From: wilpshire parish council <wilpshireparishcouncil@gmail.com>
Sent: 31 August 2018 07:04
To: planning; wilpshire parish council
Subject: Comments on Planning Applications

3/2018/0643 Proposal: Proposed conversion and extensions to the former care home to create four dwellings at 10 Knowsley Road, Wilpshire.

Drawing file: planx_downloads / 18_0643_Proposed_Site_Plan.pdf

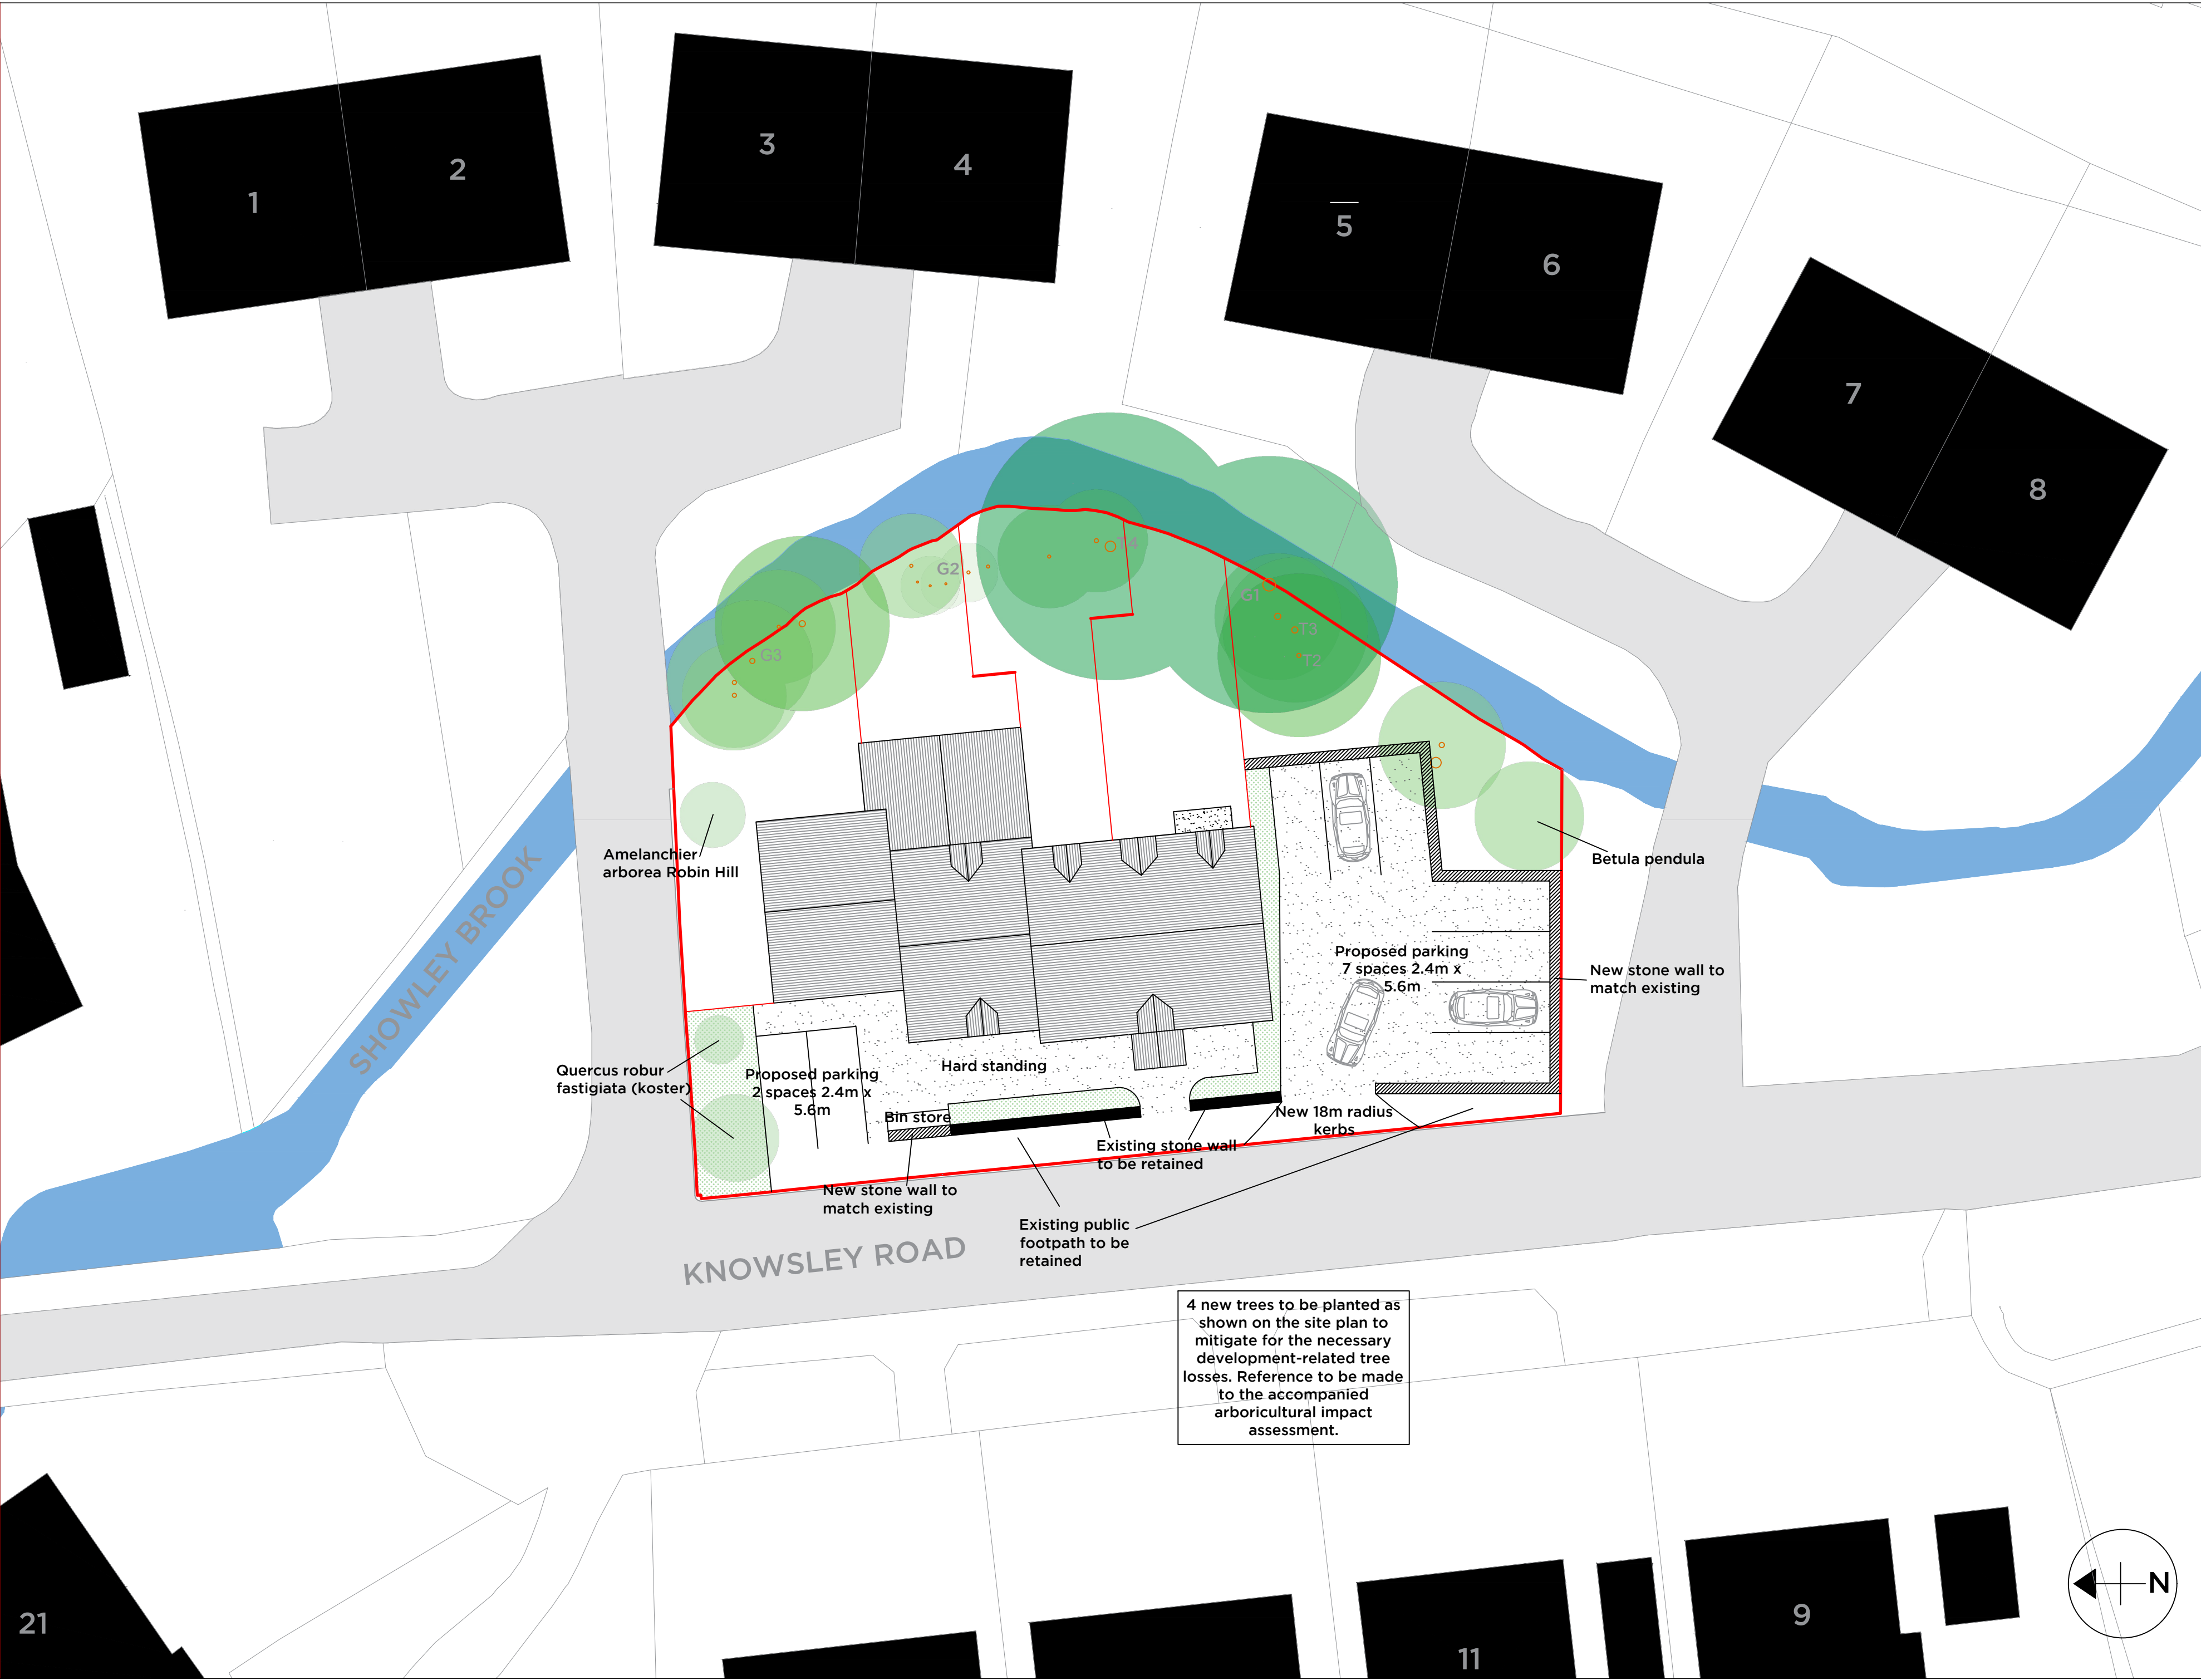
WPC - No objection but would like to see a planting scheme to screen the parking area.
